SGHS comments on Applicant's responses to Deadline 1 Submissions GH8.1.15

SGHS comments on Applicant's responses to Written Representations GH 8.1.13

Title: Figure 3.2 Important Hedgerows

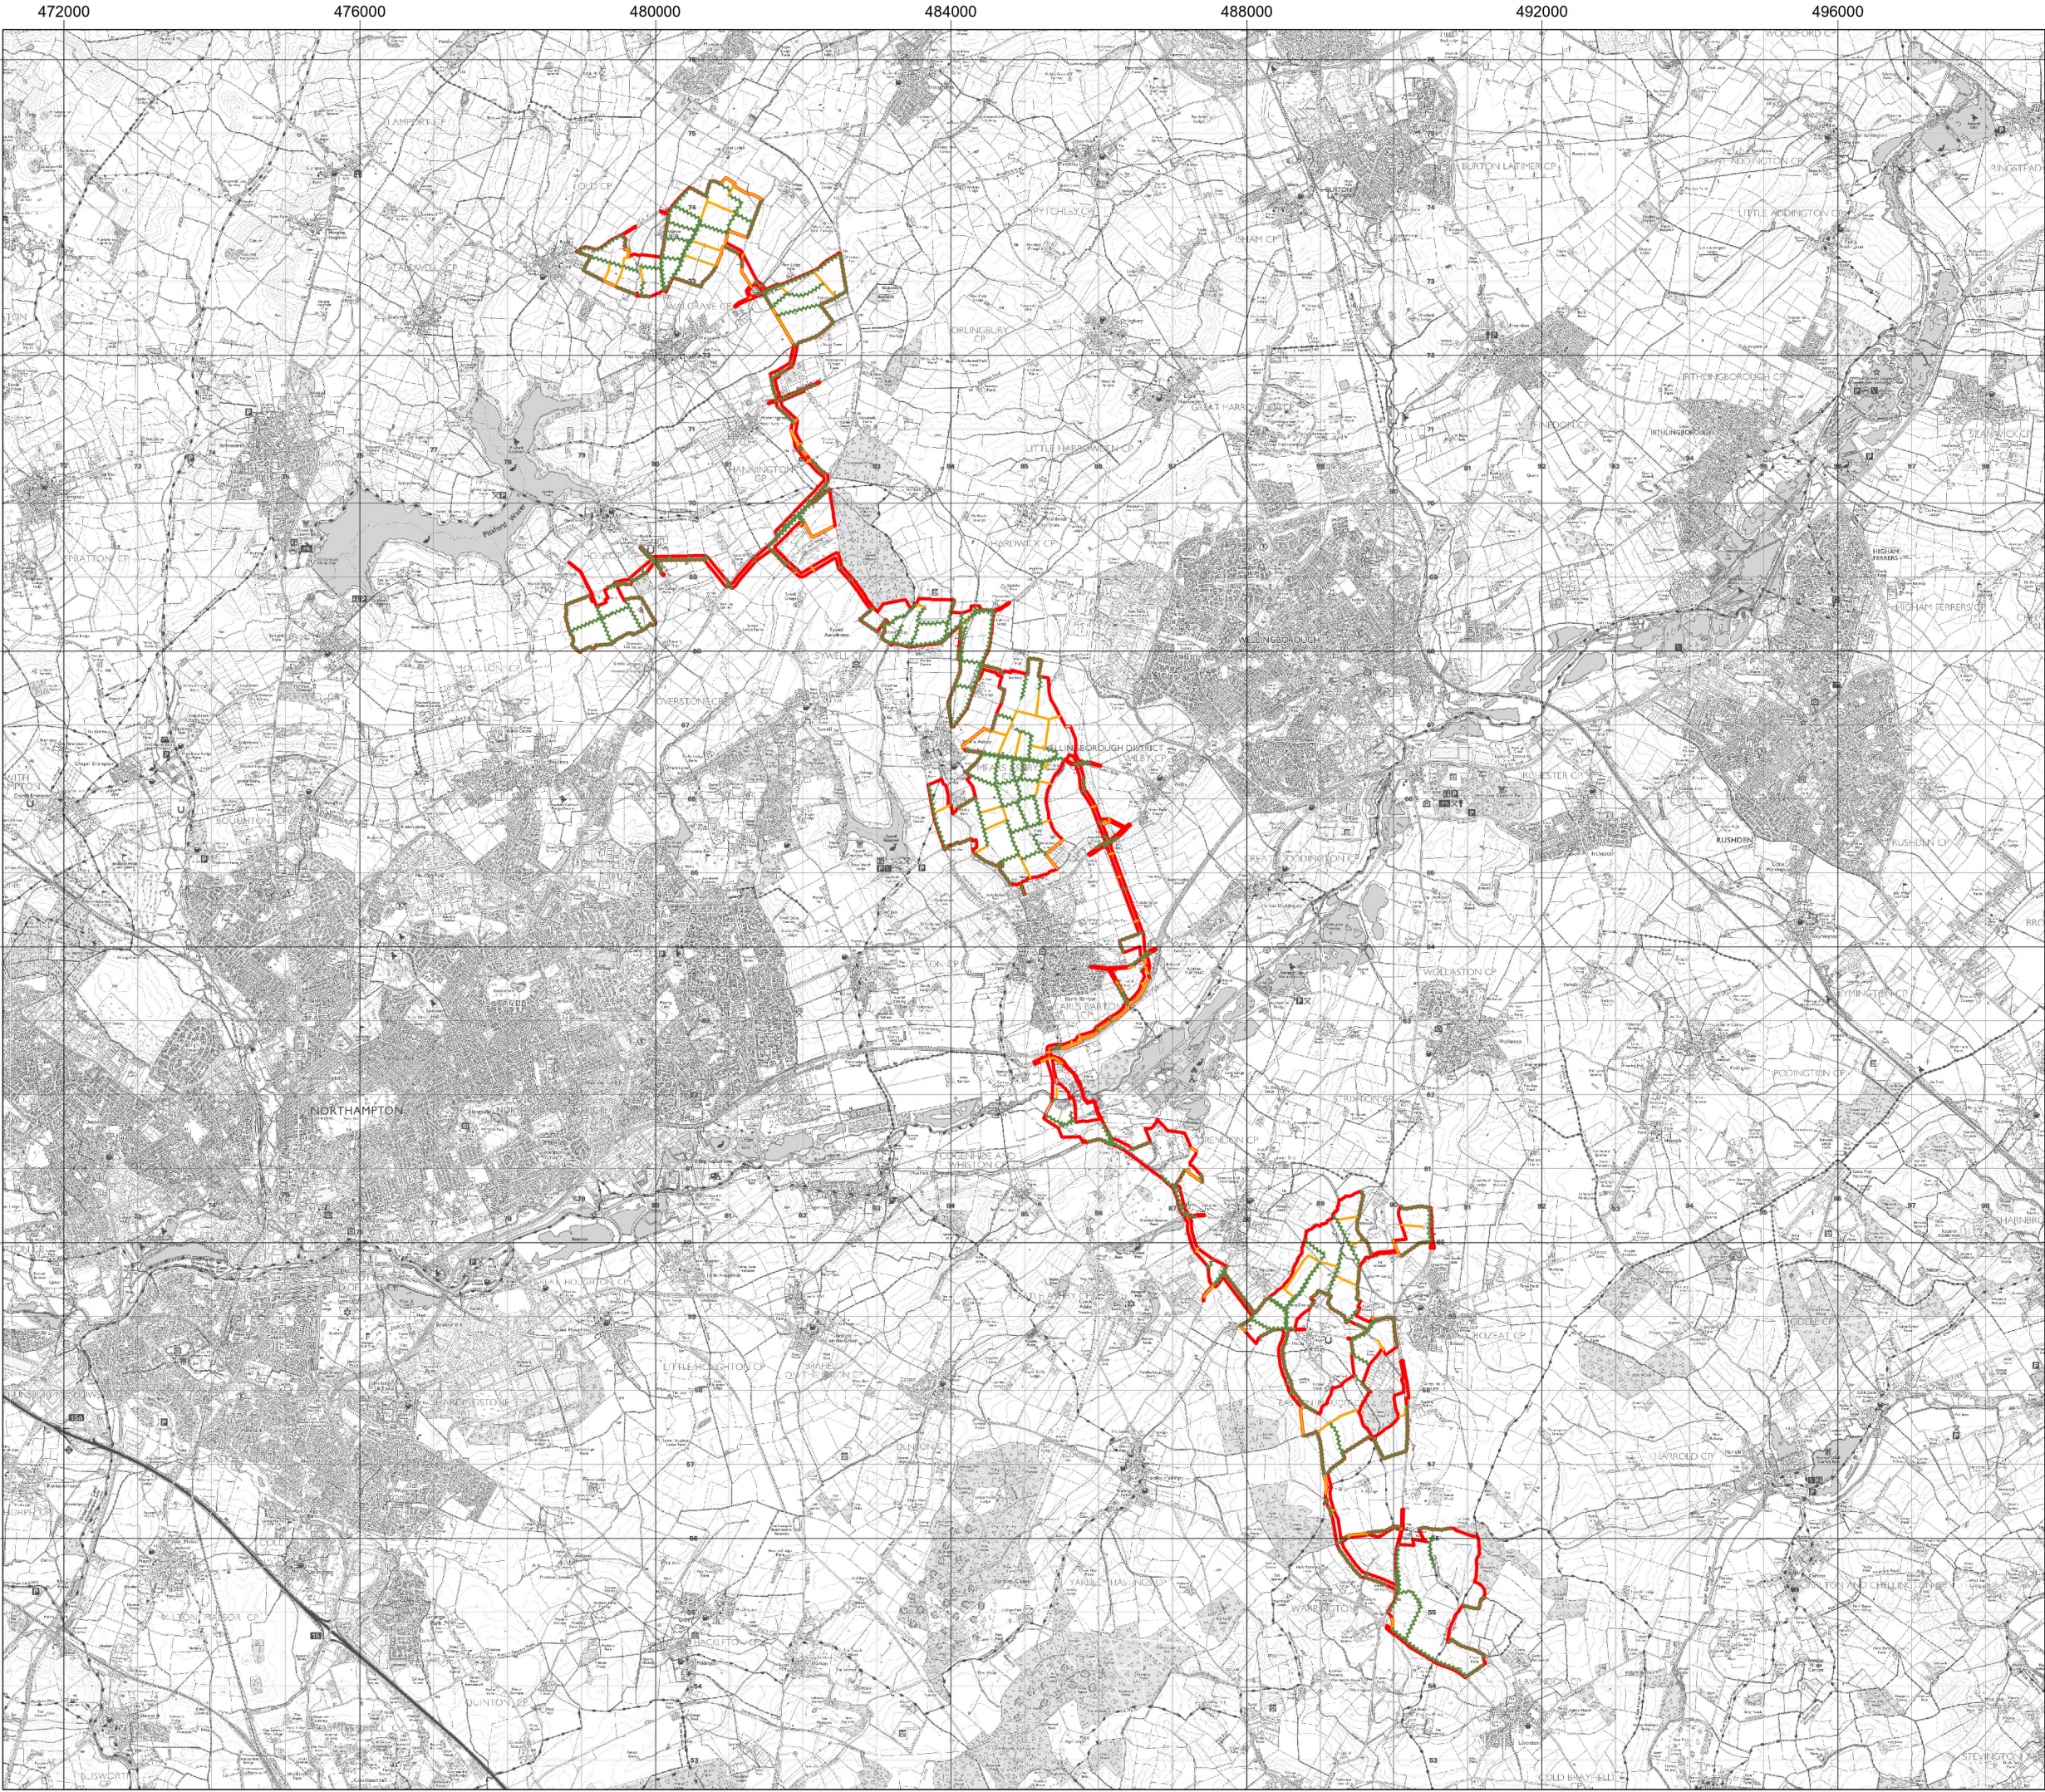
In Site A, there will be significant damage to the relevant important hedgerows, as stated in my OFH submission, from long local knowledge and bird observation. I am not in a position to comment from personal knowledge about the effects on other sites.

Other Red listed birds include the yellowhammer, grey partridge and dunnock. **Yellowhammer are known to nest every year in the hedgerows in eg Site A – particularly along Newland Road adjacent to field AF29, where the crossing point A-1 is planned. It will not be possible to provide a sufficient buffer for these birds given the heavy vehicle movements required to bring all equipment and plant to the west side of Site A.**
